Item No. **Report of the Head of Planning, Building Control, Sport & Green Spaces**

Address 734-736 UXBRIDGE ROAD HAYES

Development: Change of use of first and second floors from offices (Use Class B1) to a 9 bedroom House in Multiple Occupancy (Sui Generis), involving installation of roof lanterns to first floor roof and installation of metal gates to side

LBH Ref Nos: **18920/APP/2015/3521**

734 - 736 Uxbridge Road
proposed change of use to form HMO
1:100@a3
APR 2014
sd00738/PL08 RFV B

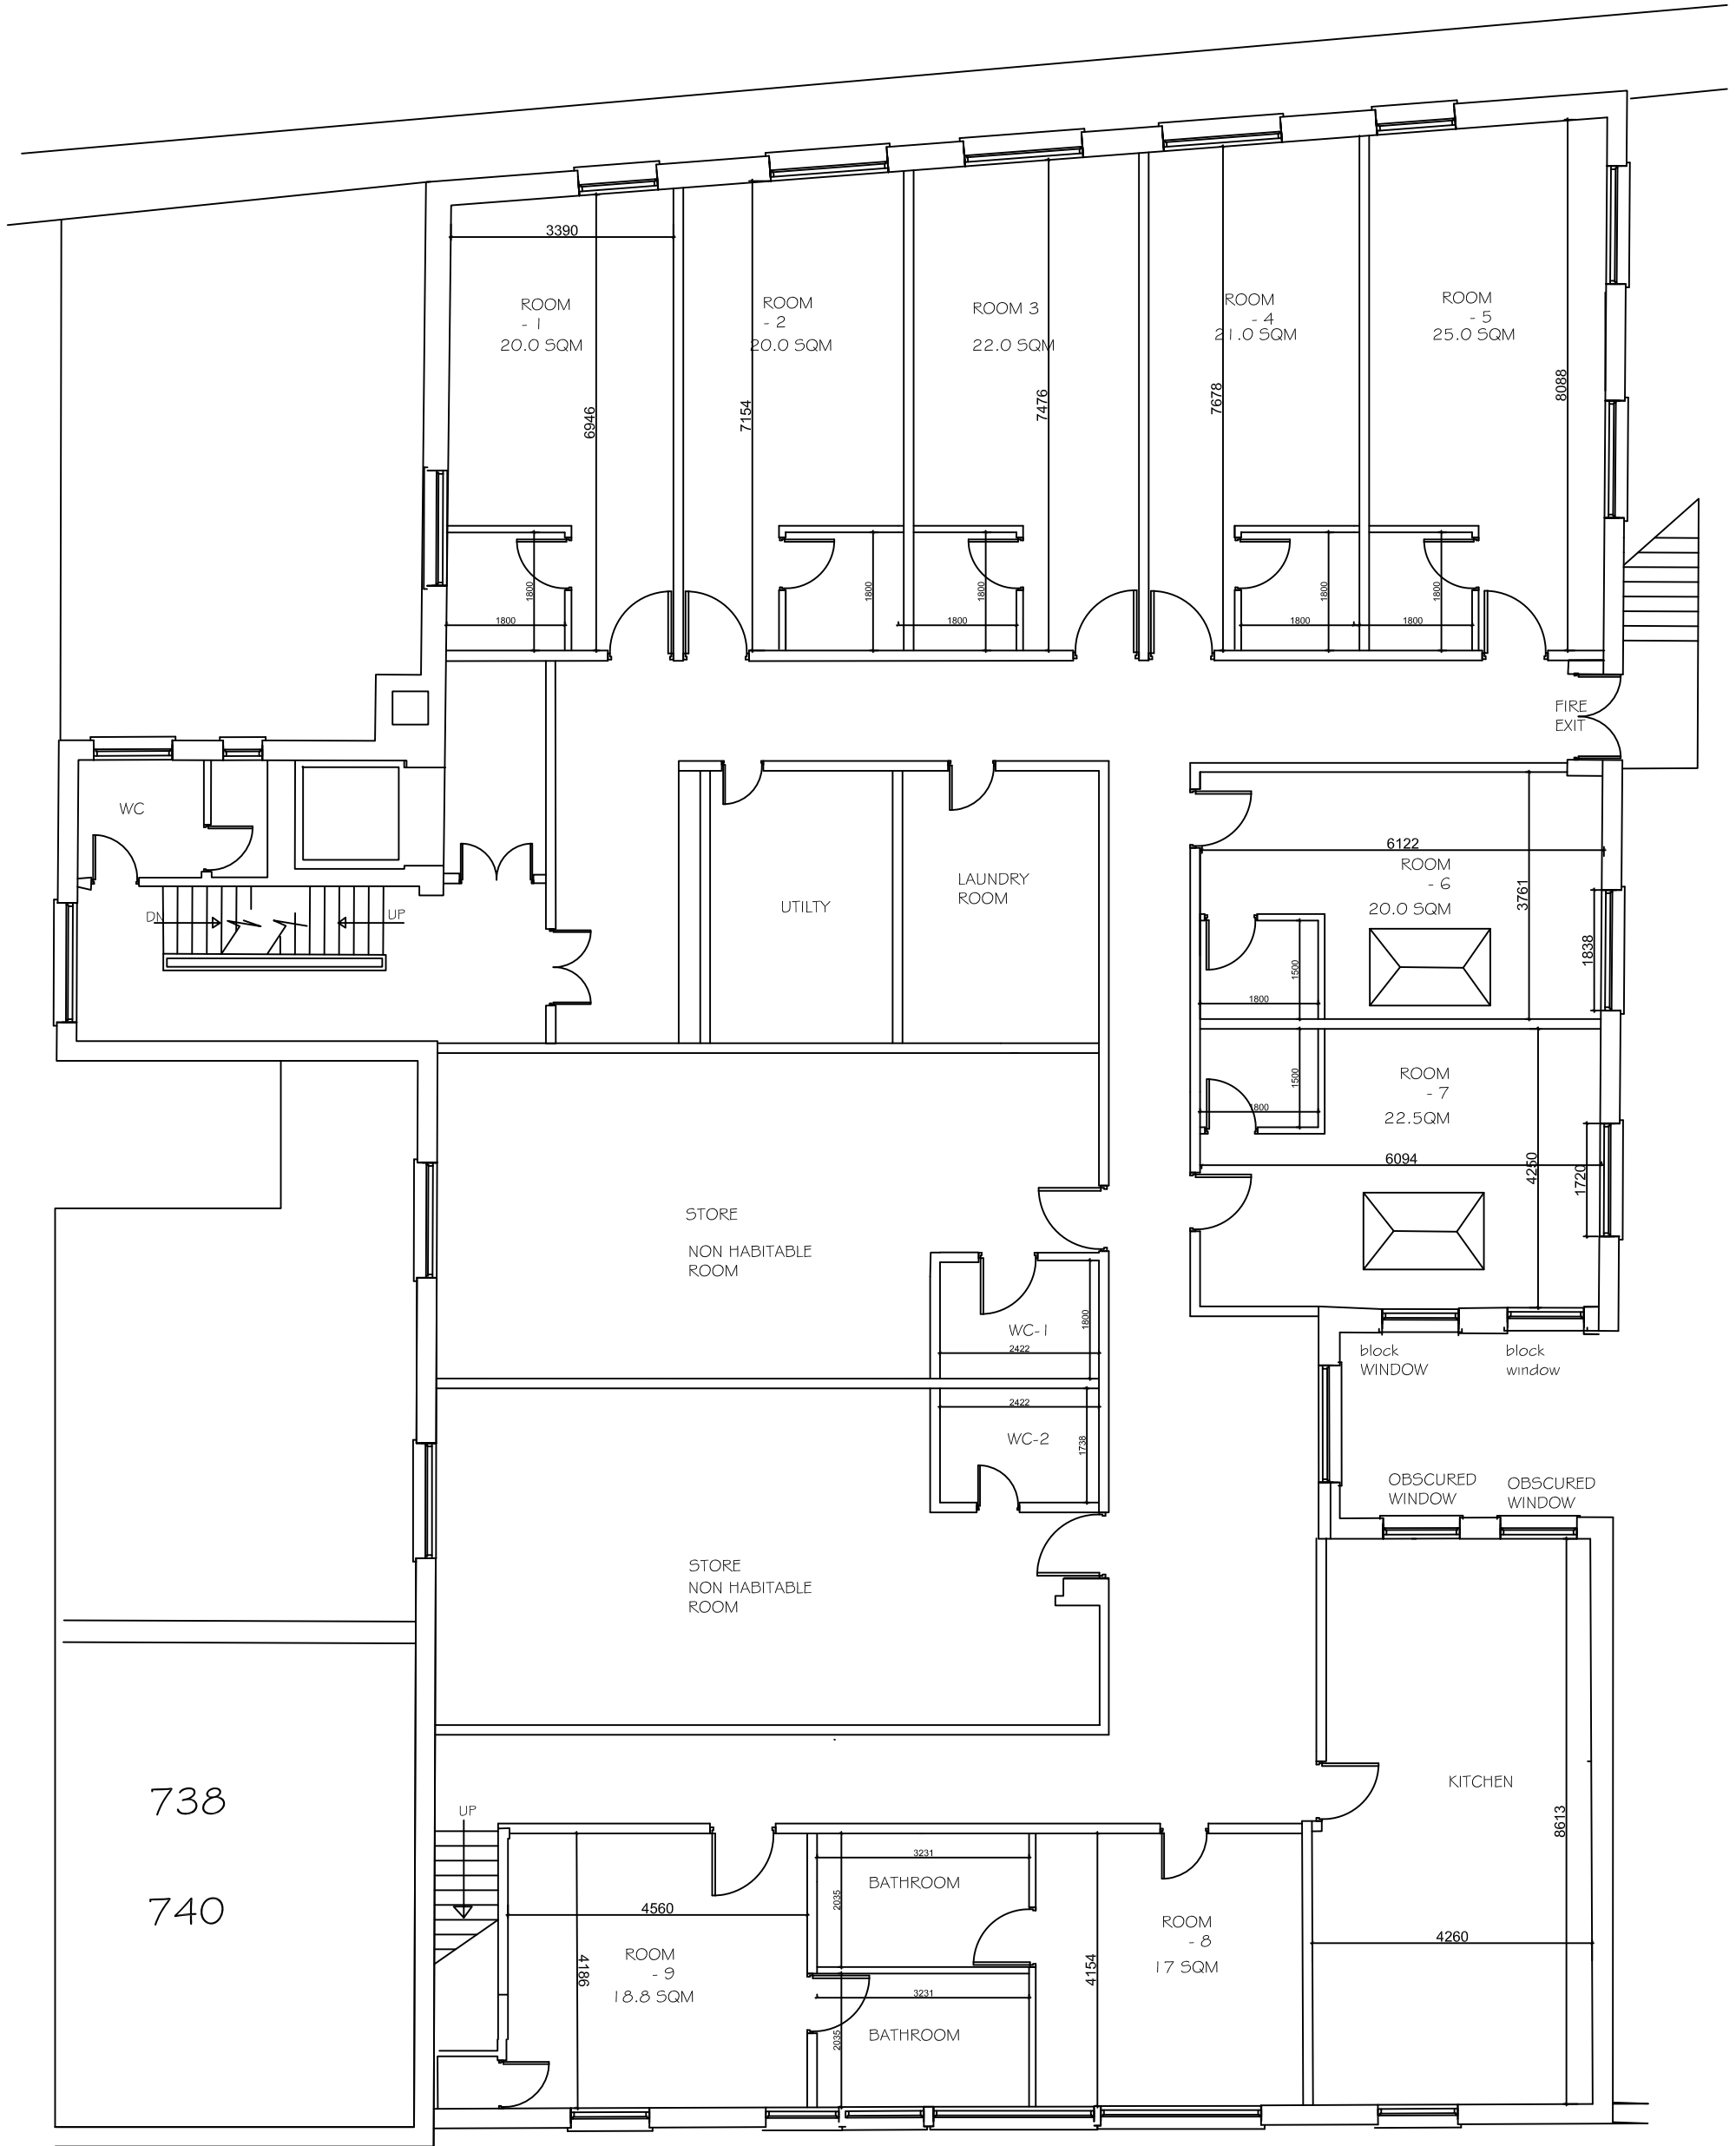
1) There is a lack of detailed information on how many set of cooking facilities would be provided in the communal kitchen in order to meet our prescribed standard of 1 (kitchen set): 5 (people), it appears that the all the bedrooms are capable of accommodating 2+ people, and assuming there are 2 people in each room, there would be 18, hence a minimum of 4 set of cooking facilities would be required and to be demonstrated. I would suggest to request the applicant to provide such information. FYI, a set of cooking facility includes 1 x 4 rings cooker, a 1.5m length worktop and a sink with drainer.

2) I have concern regarding fire separating between the proposed bedrooms 8 & 9 as the bathroom of room 9 would be constructed long a 2-3 sets of windows with stud partitions perpendicular to them and this would create a bridged area for smoke and fire to pass through the window internally. Suggest applicant to revise drawing to indicate windows perpendicular to the stud partitions are to be bricked up or internally protected to achieve 30mins fire resistance.

Officer comment: Amended plans have been submitted to address the above points.

sd00738/PL09
REV D

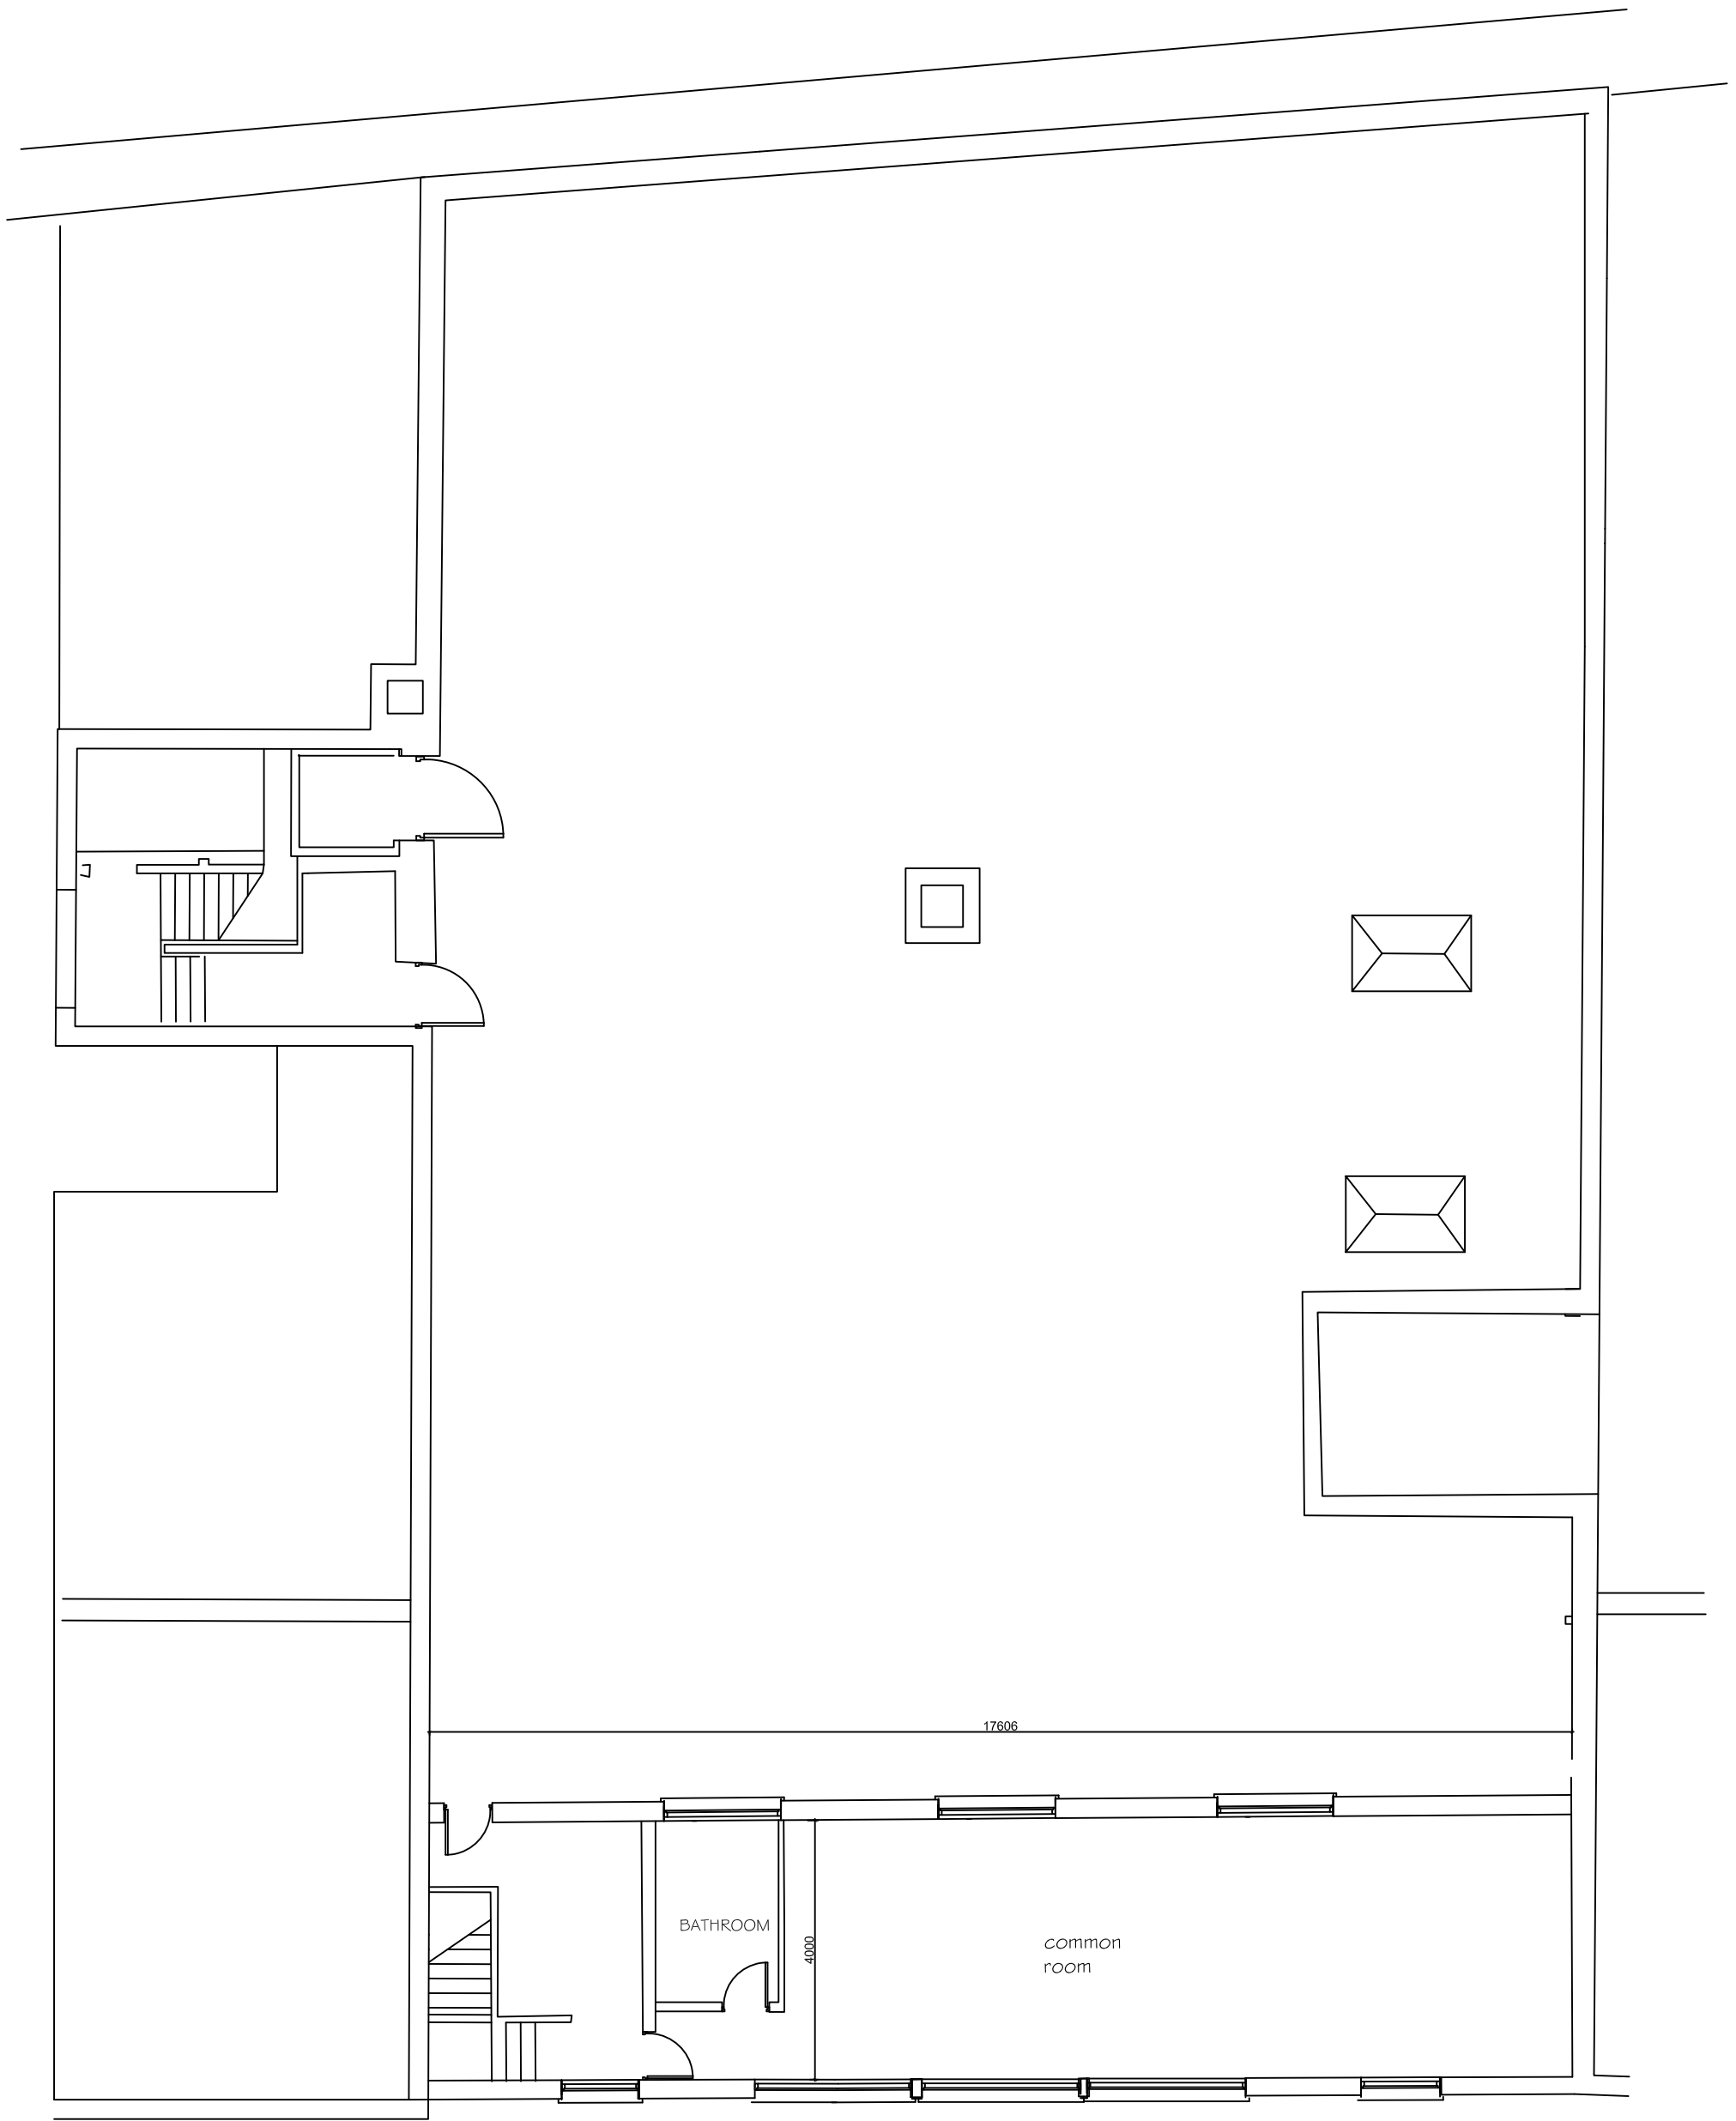
The general arrangement and room layouts are consistent with the Council guidance on HMO's, including the provision of a relatively large 49sq.m communal living space (with front outlook) and a kitchen area with front outlook and rear obscure glazed windows measuring 35m². The scheme has been revised since the former refusal to provide a daylighting assessment. The Inspector's comments in relation to the issue of the adequacy of the living condition of the occupants of the HMO is a material consideration which states:

A daylighting Assessment has been submitted to demonstrate that the levels of daylight are acceptable to the occupants of rooms 6 and 7. The re-arrangement of the internal layout to locate the kitchen and common room with front facing windows, overcomes the previous concerns in relation to the refusal of the previous application on the grounds of poor outlook. In summary therefore, the occupants of the property would enjoy acceptable living conditions in accordance with London Plan Policy 3.5.
